Consultation Response from KC, Conservation and Design		
2021/91638 Land at Hart Street, Newsome, Huddersfield, HD4 6LS		
Reserved matters application pursuant to outline application no.2016/91479 (appeal no. APP/Z4718/W/17/3173711) for erection of 22 dwellings		
Date Responded:02.06.21	Responding Officer: NG	Responding Ref:

PROPOSED
HIGHWAYS PLAN

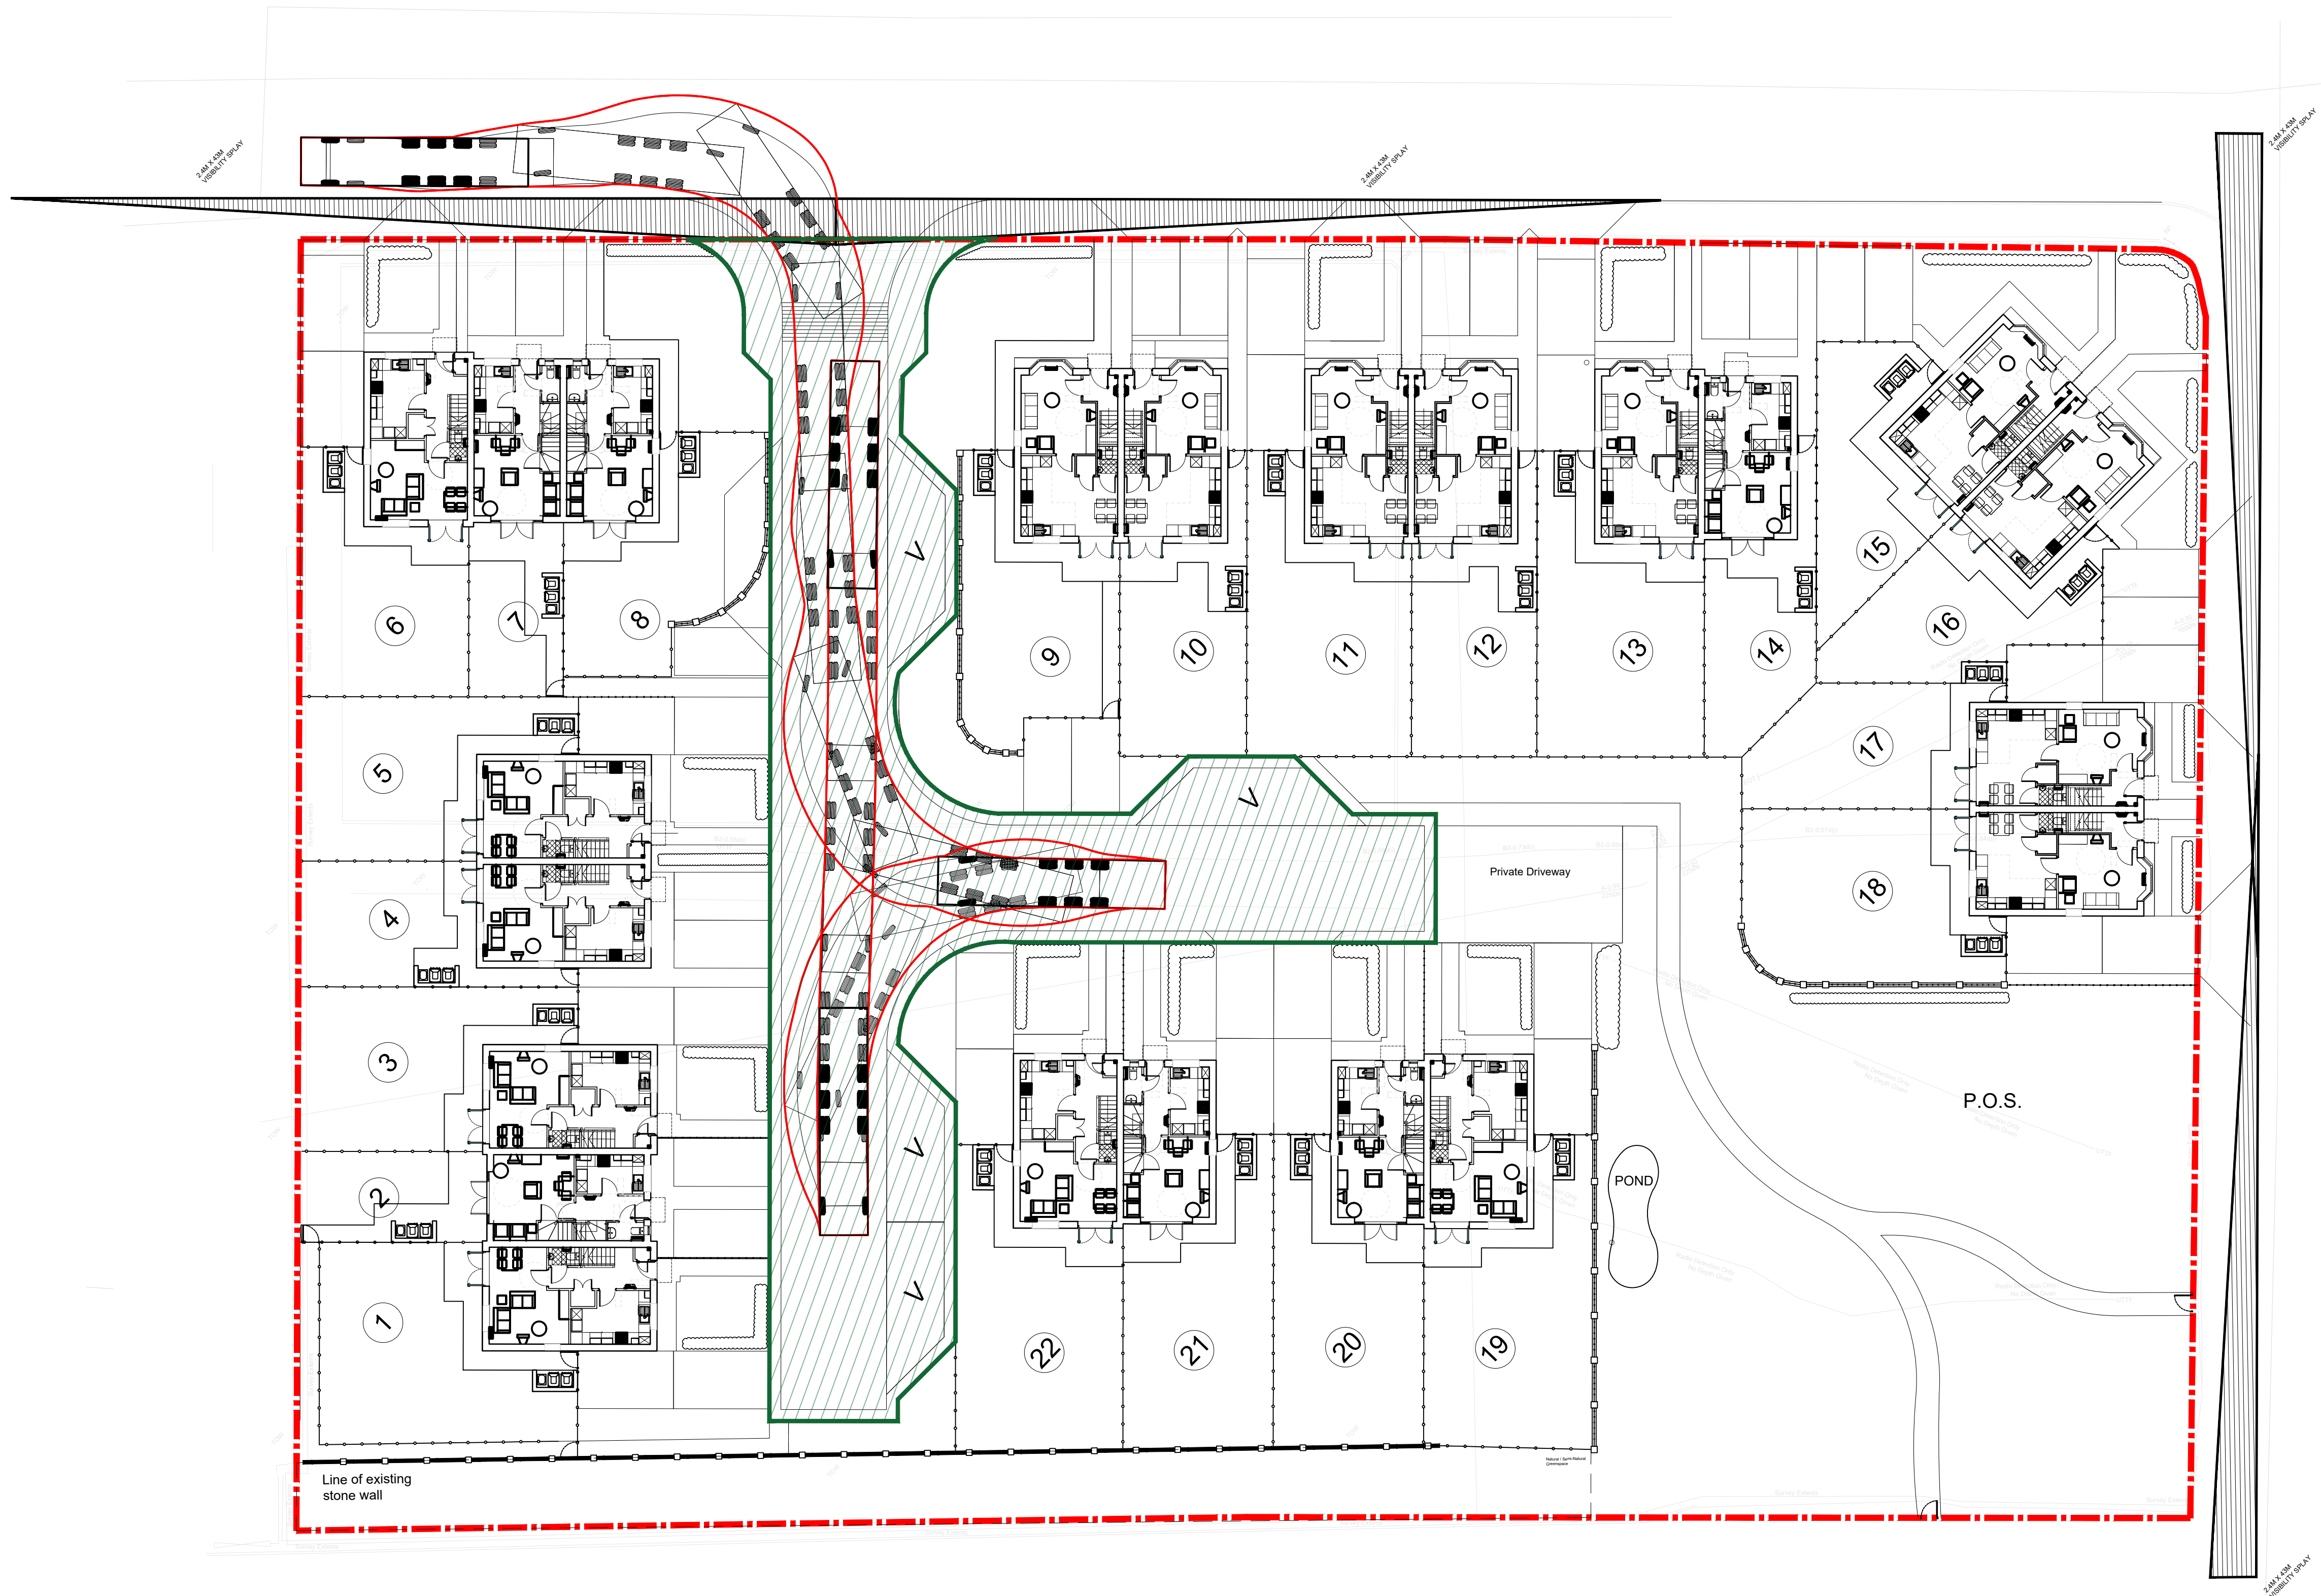
2. Poor outlook for units 19-22 as they essentially look into a service yard and rear fencing.
3. Unnecessary over-reliance upon on-street parking, effectively creating two parking courts in the body of the site which would dominate the site's character.

5. Lack of detail of the cross-site access from Naomi Road to Hart Street. It is unclear whether or how the parking areas and cul-de-sac ends will provide cross-site pedestrian access and, if not, how the edge of Naomi Street would be enclosed.

7. The proposed on-site parking arrangements are contorted and would result in the body of the site effectively becoming dominated by a hard surface car-park, which would diminish the value and useability of the public open space.

9. There are no street trees on the roads and the proposals lack details of surface materials and apparent domination of hard-surfaced parking.

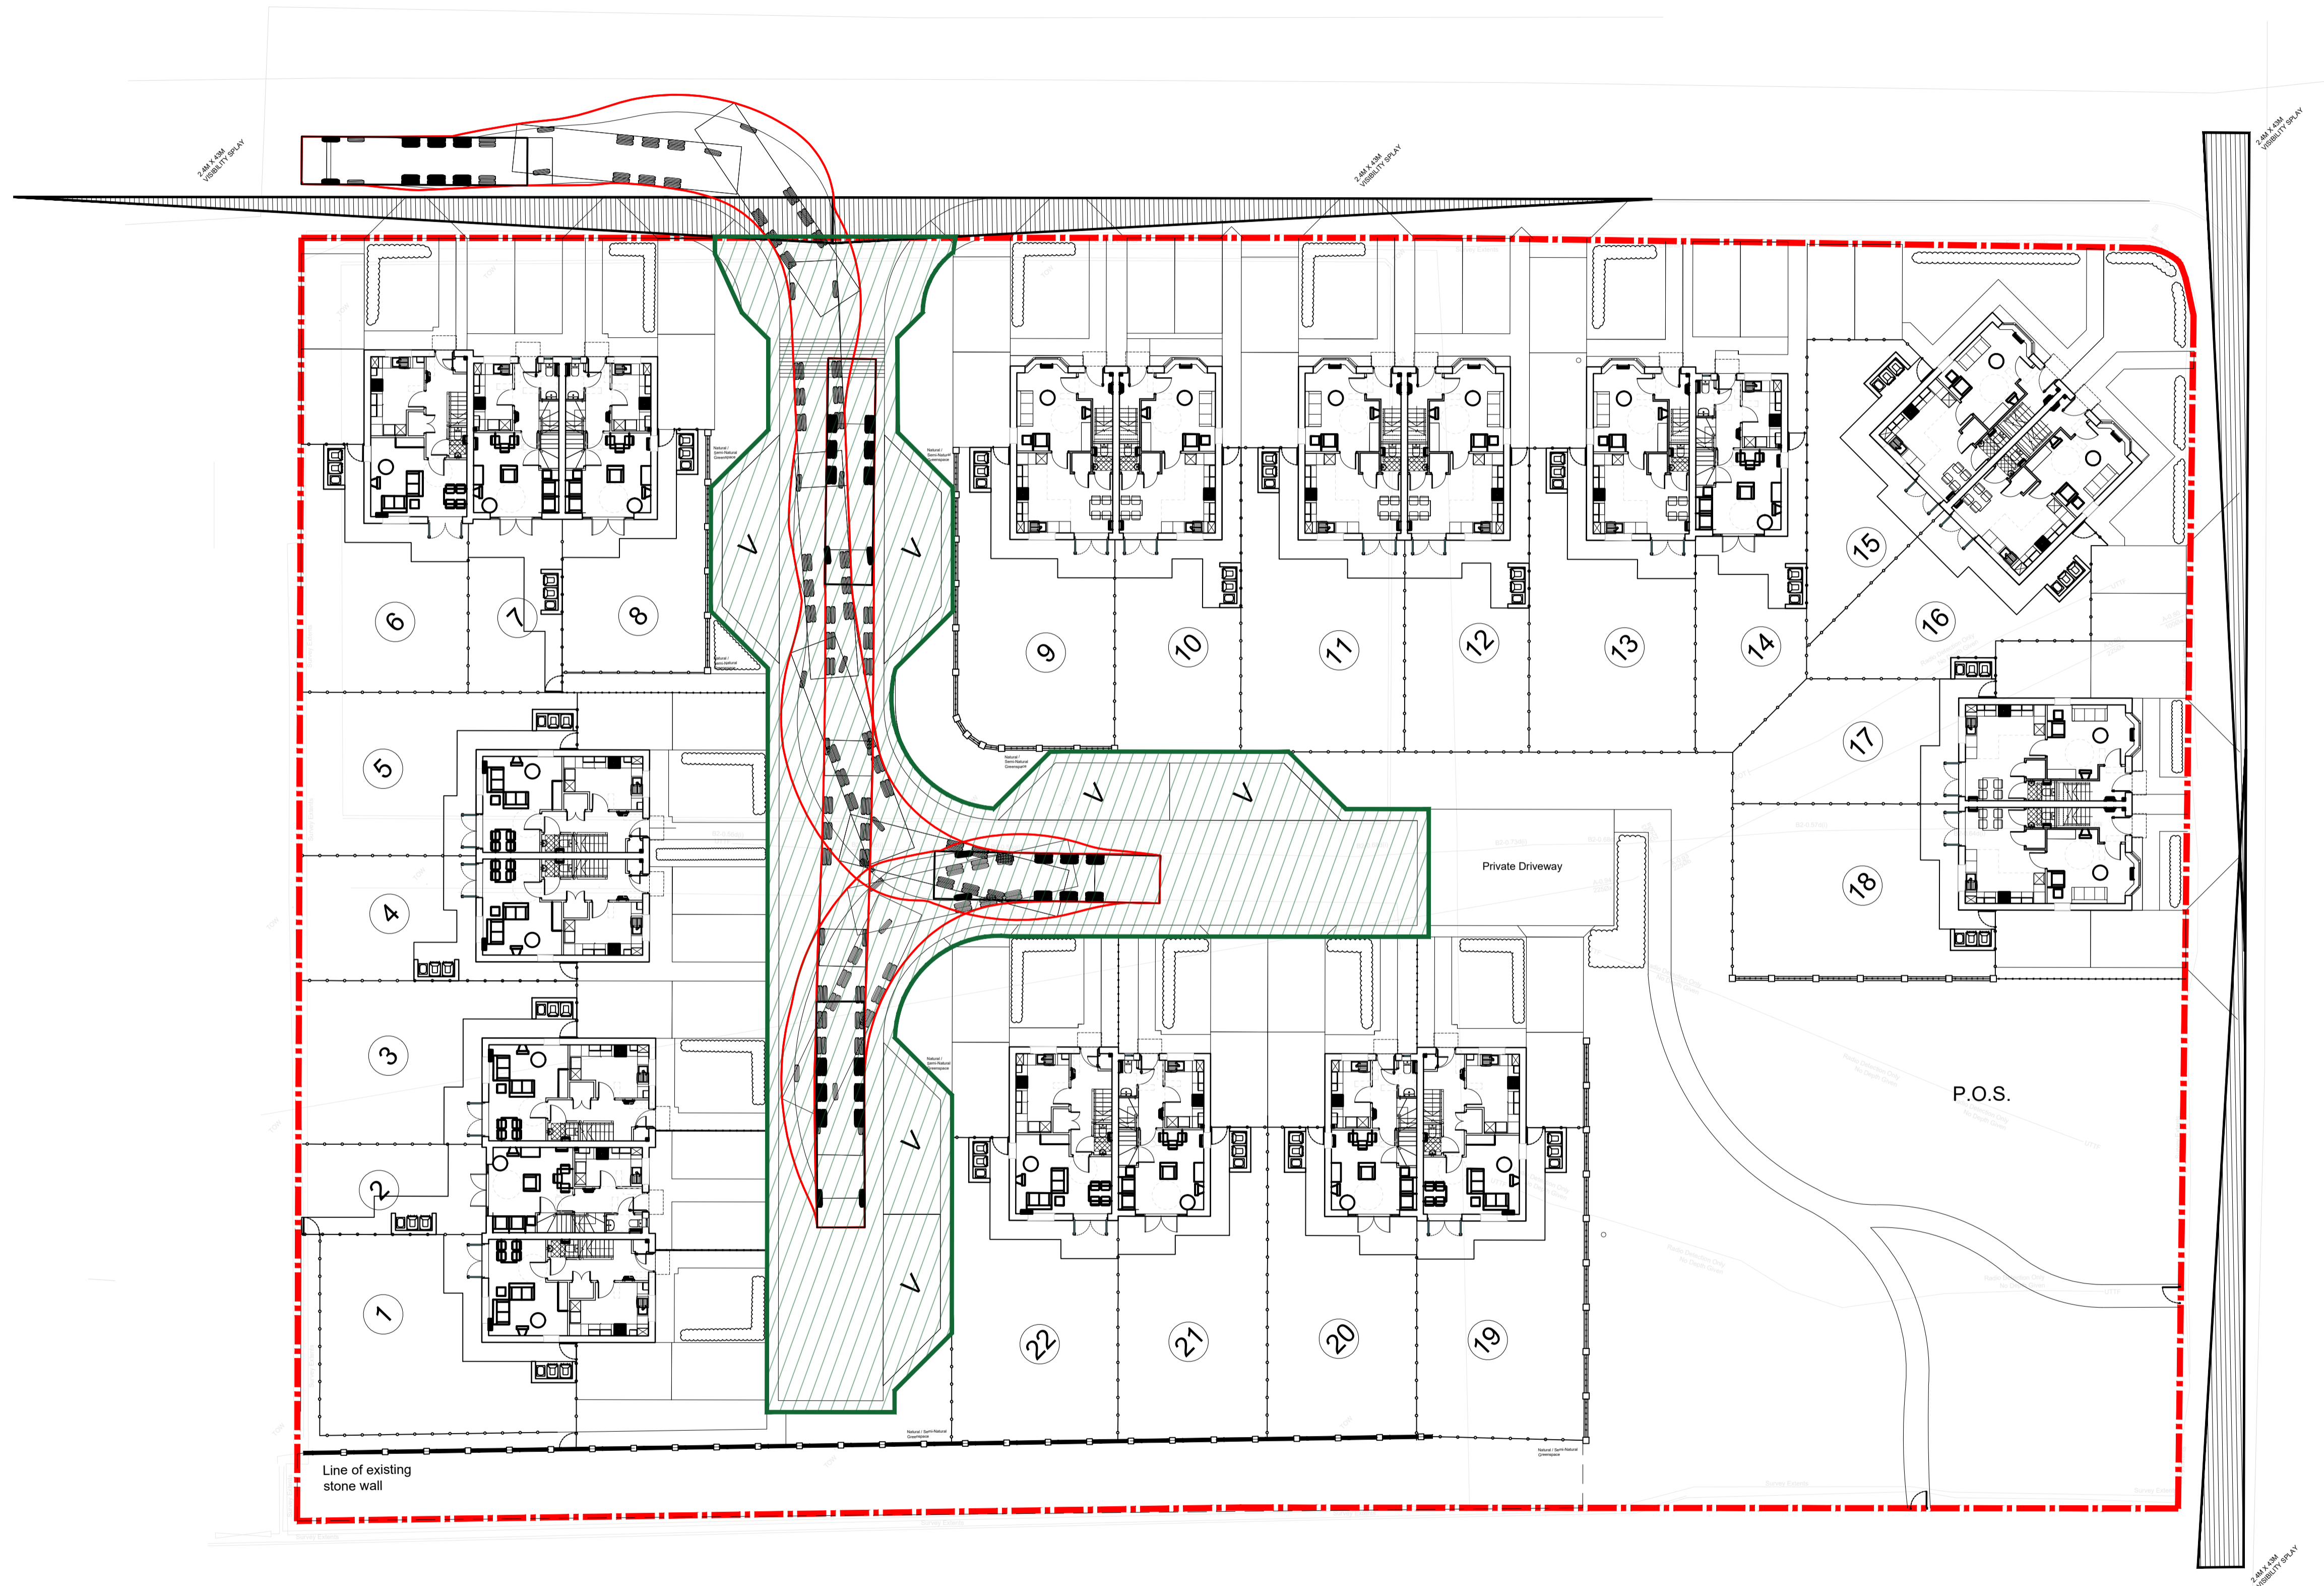
1. Poor arrangement of units 14.15.1,6 to the corner of Hart Street and Newsome Street. This is a prominent location and would merit greater design consideration to positively address the corner.

4. Lack of detail of boundary treatments on all edges, including the Newsome Street frontage and the former lane/alleyway which services the properties fronting Ruth Street.

6. Lack of details of the cross-site accessibility from Newsome Road. It is unclear how the 'public open space' will be enclosed and its relationship with development.

8. No detail of the layout and purpose of the public open space (habitat? Play space?). No details of how the public open space would be designed, integrated into the development, managed or maintained.
